PORTLAND MAINE

September 9, 2008

RE: 143 Craigie Street – 120-B-008 – R-3 Zone – Application #08-1131

CROSS SECTION X-X SEE SHEET #2

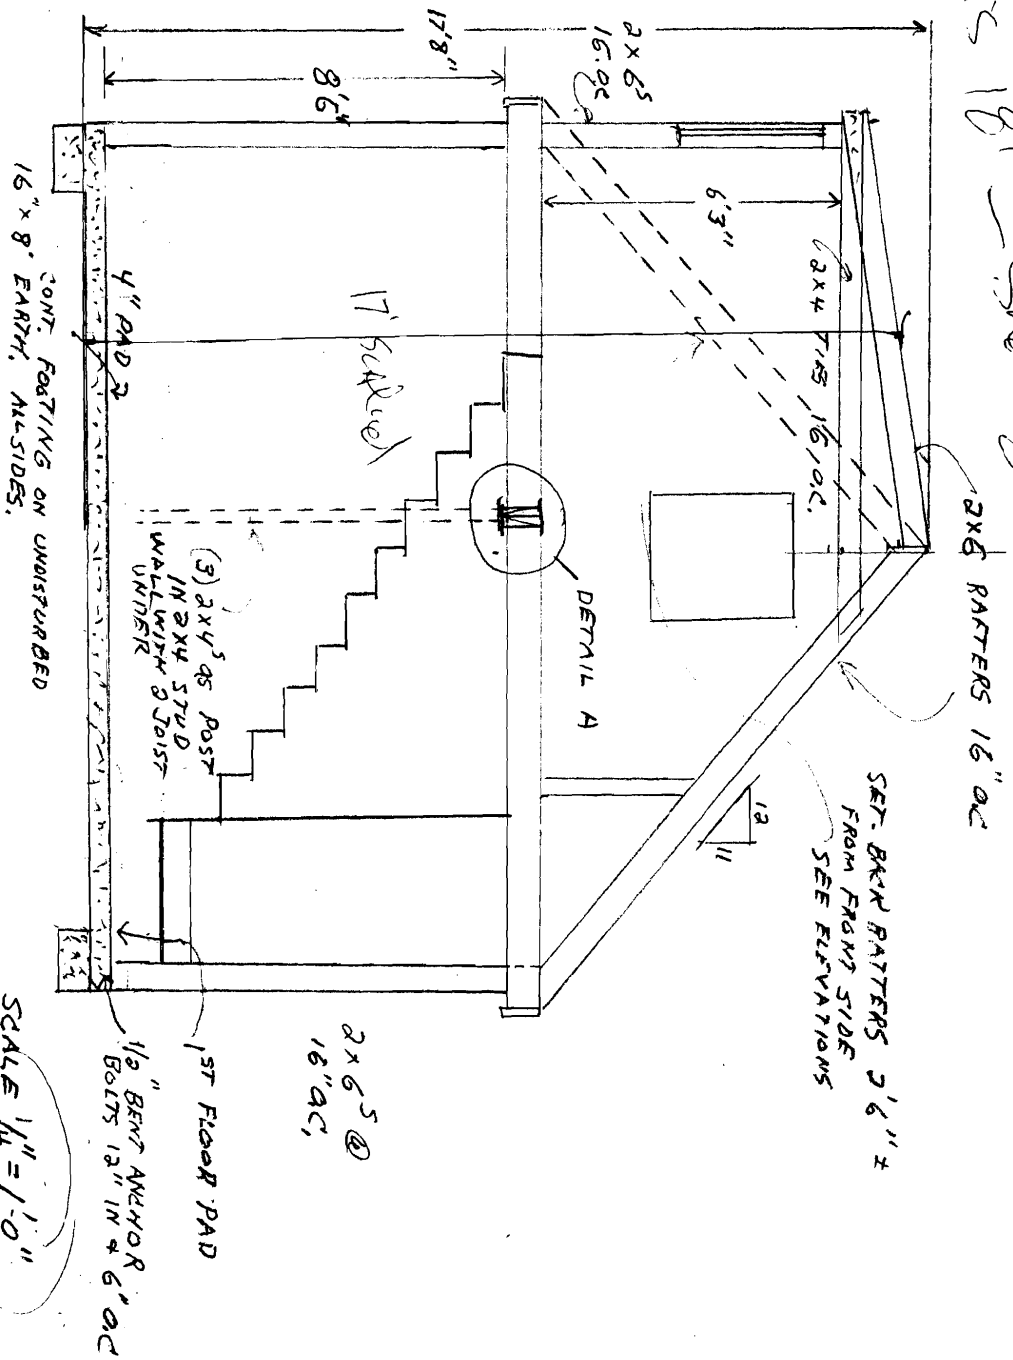
Finally, section 14-90(g) states that detached accessory structures shall be no higher than eighteen (18) feet. Your submitted plan, accounting for grade differences, scales to be at least twenty (20) feet in height.

FRONT ELEVATION

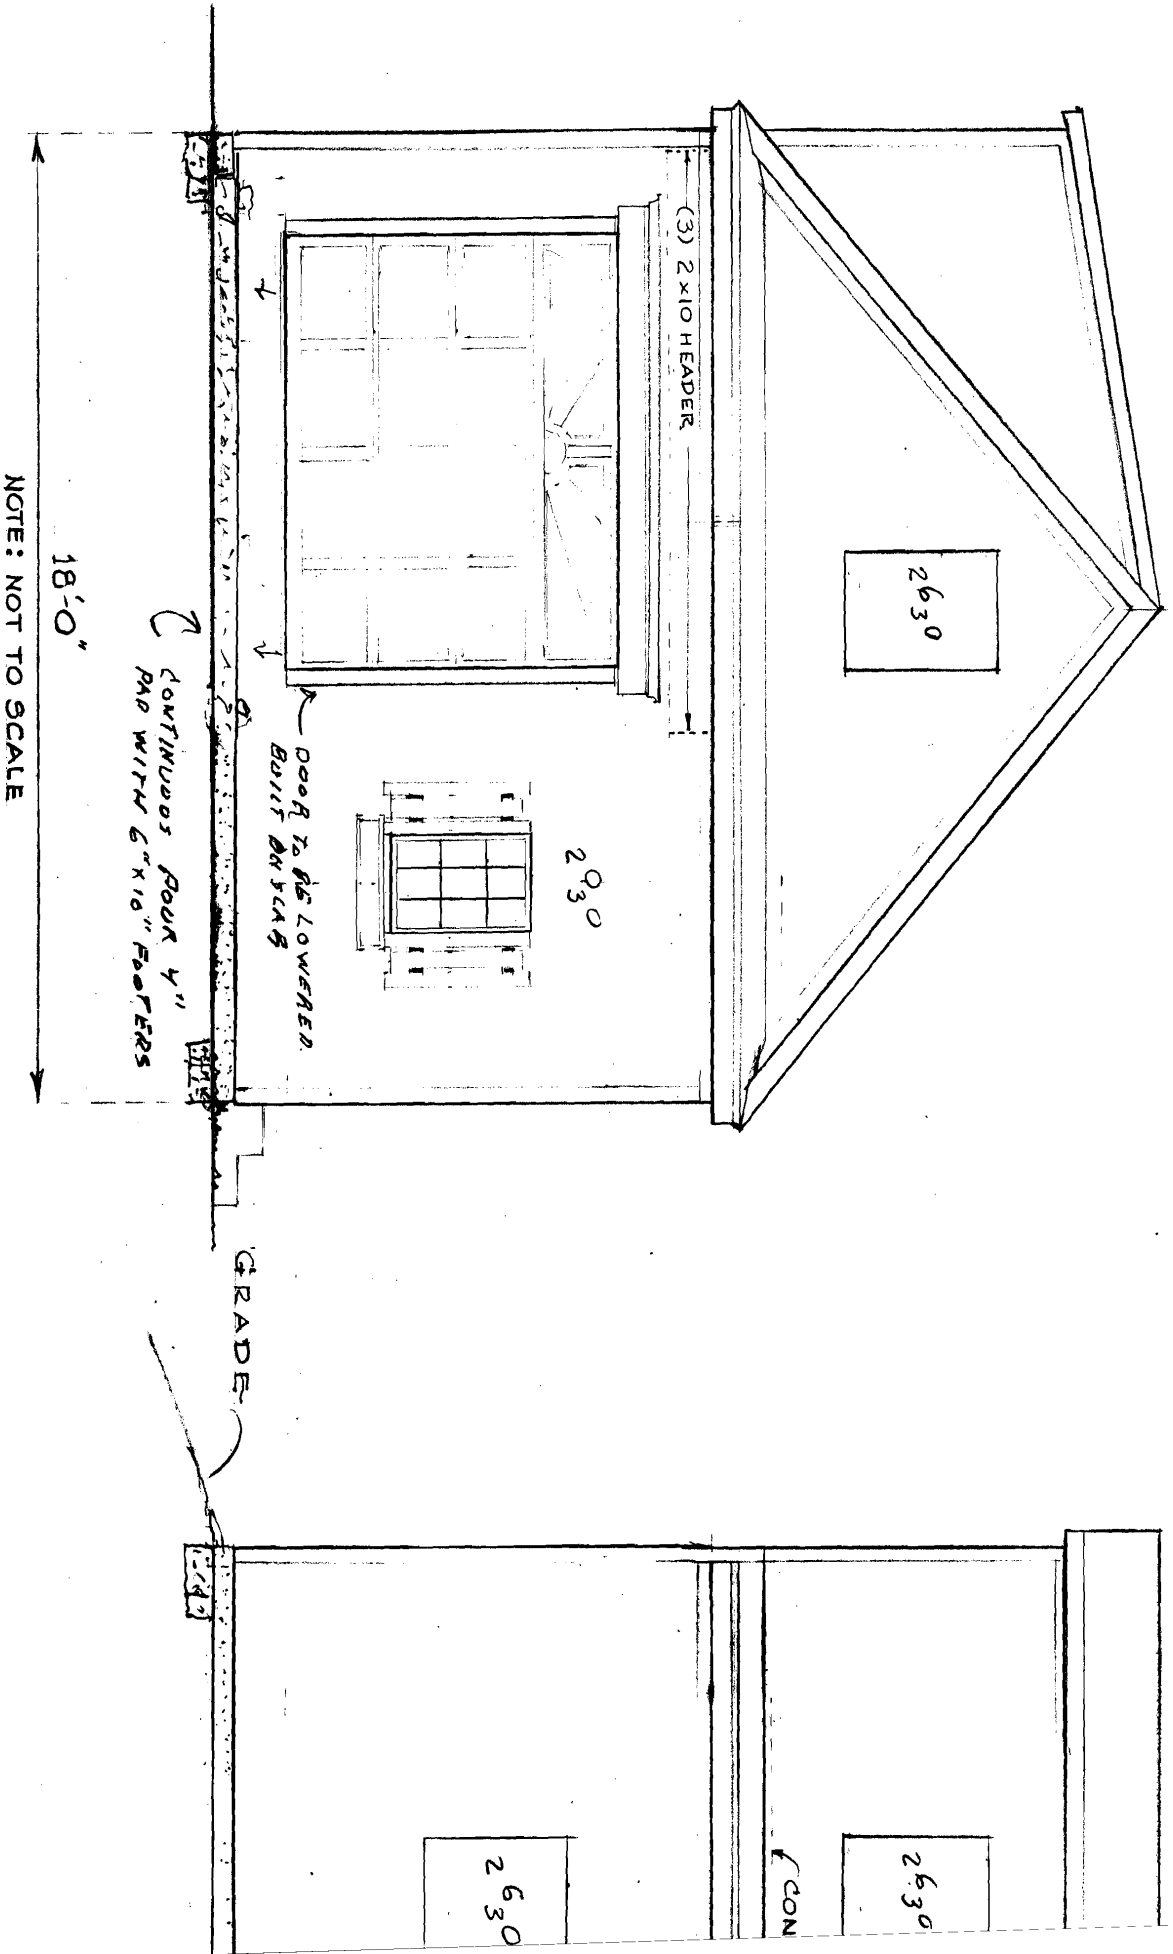
First of all, the submitted information is not consistent. The submitted building elevation plans show a garage of 18' x 22' where the submitted site plan shows a garage 20' x 22'. Your site plan also shows an entry door to the left of the garage door. The elevation drawings do not delineate that entry door. All your submitted plans must be consistent for an accurate analysis and review with current regulations. You must submit revised plans reflecting exactly what you are requesting and what you expect to build. Those plans must be consistent.
